From: [Bill Booker](#)
To: [Price, Robert](#)
Cc: [Simon Cope \(simon.cope@eurogarages.com\)](#); [Tim Hancock](#); [Wilson, Andy](#); [Betts, Simon](#); [A38 Derby Junctions](#)
Subject: RE: Statement of Common Ground
Date: 02 April 2020 11:56:07
Attachments: [image004.png](#)
[A38 Derby Junctions Scheme.msa](#)

I have been able to take instruction from EGL on this matter and have been instructed that the SoCG remains unagreed and therefore we are unable to sign the document. This is given the level of issues that are outstanding in respect of the proposed site access alterations from the A52.

From: [Bill Booker](#)
To: [Wilson, Andy](#)
Cc: [Simon Cope \(simon.cope@eurogarages.com\)](mailto:simon.cope@eurogarages.com); [Tim Hancock](#);
["Christopher.Archbold@highwaysengland.co.uk"](mailto:Christopher.Archbold@highwaysengland.co.uk)
Subject: A38 Derby Junctions Scheme

CUSTOMER TRACKS

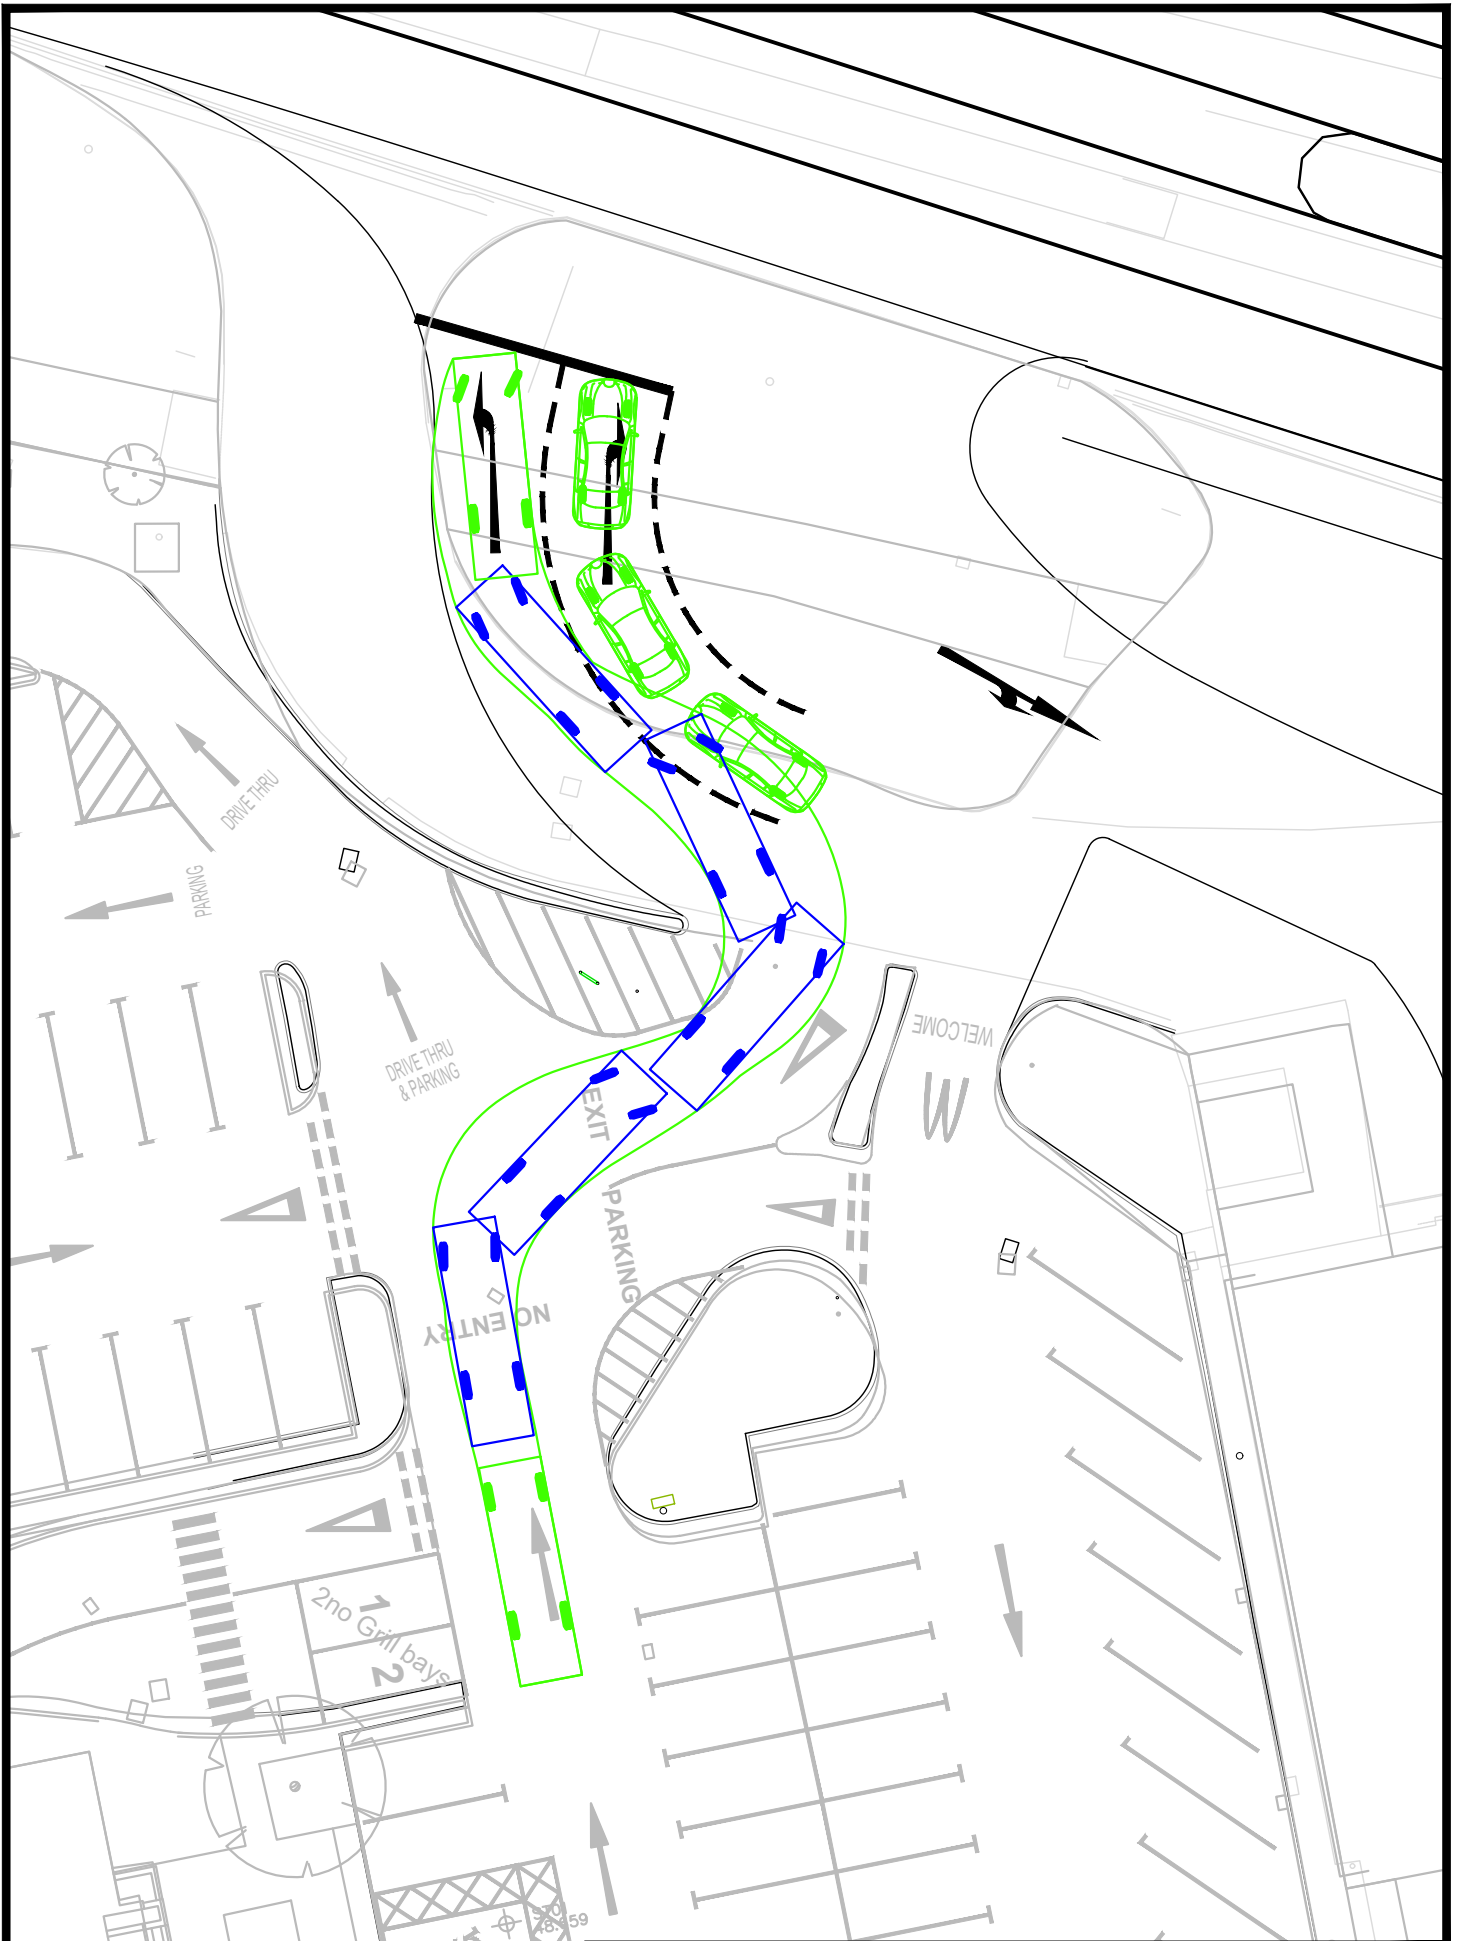
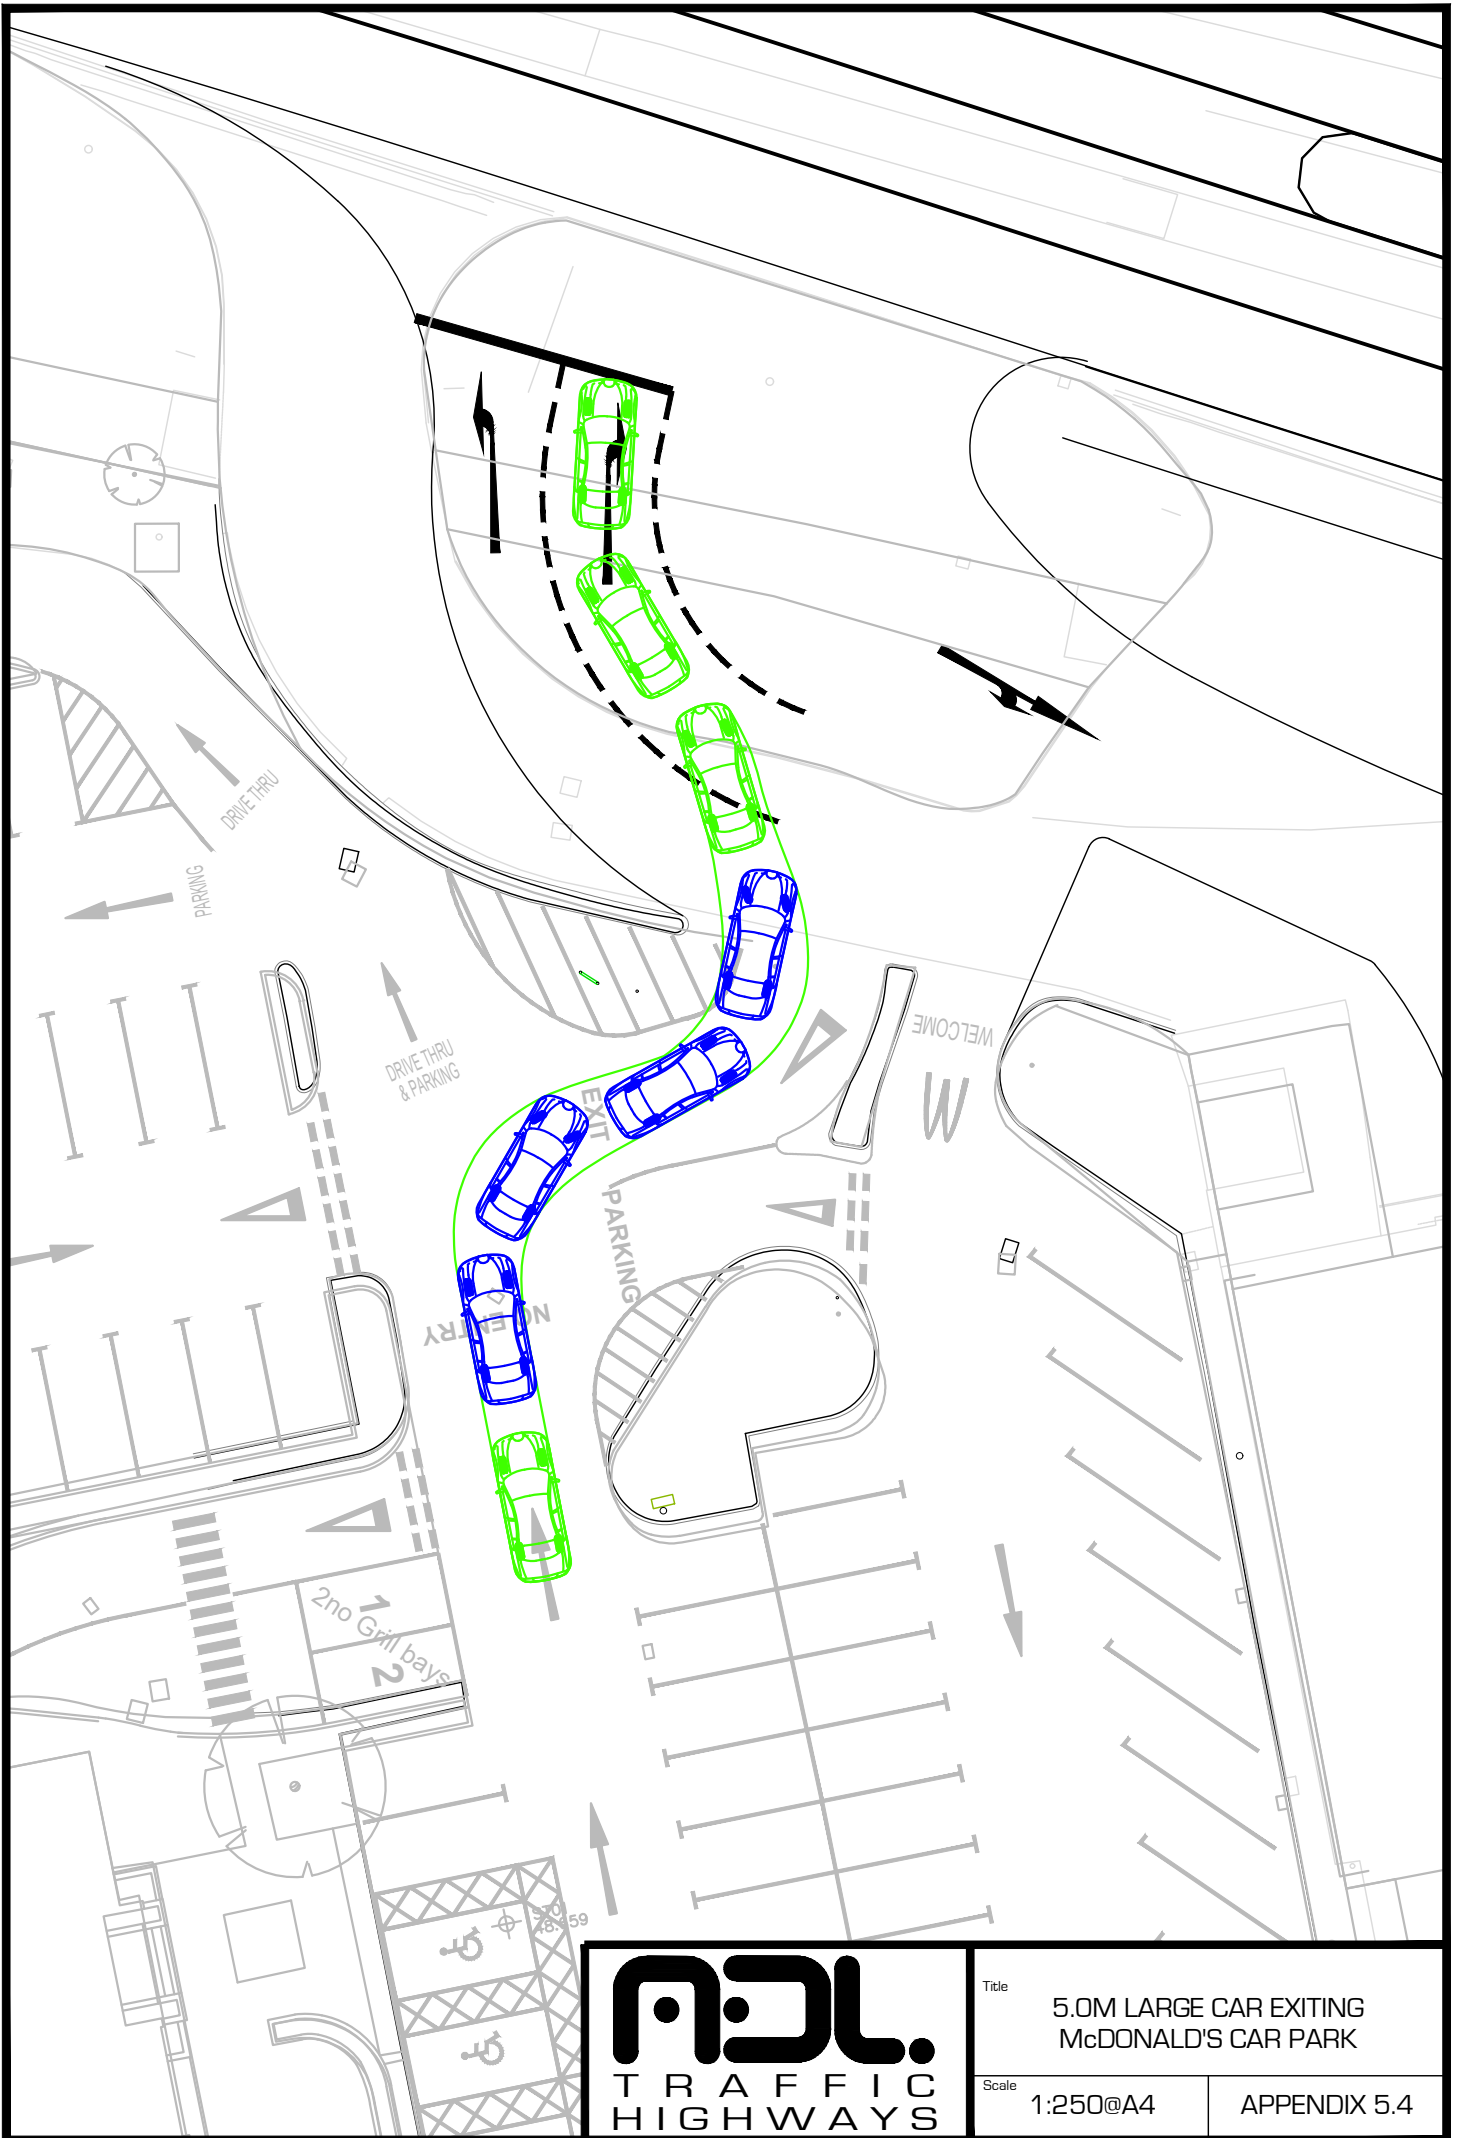
- 5) The proposed A38 ingress alterations does impinge upon the existing right of way for EGL from the A38 into their site.
- 6) The alteration to the A38 ingress requires McDonalds deliveries to use the A52 access and alters the pattern of movement within the site. The swept paths demonstrate that the McDonalds delivery vehicle would need to pass onto EGL land where there is no right of way.
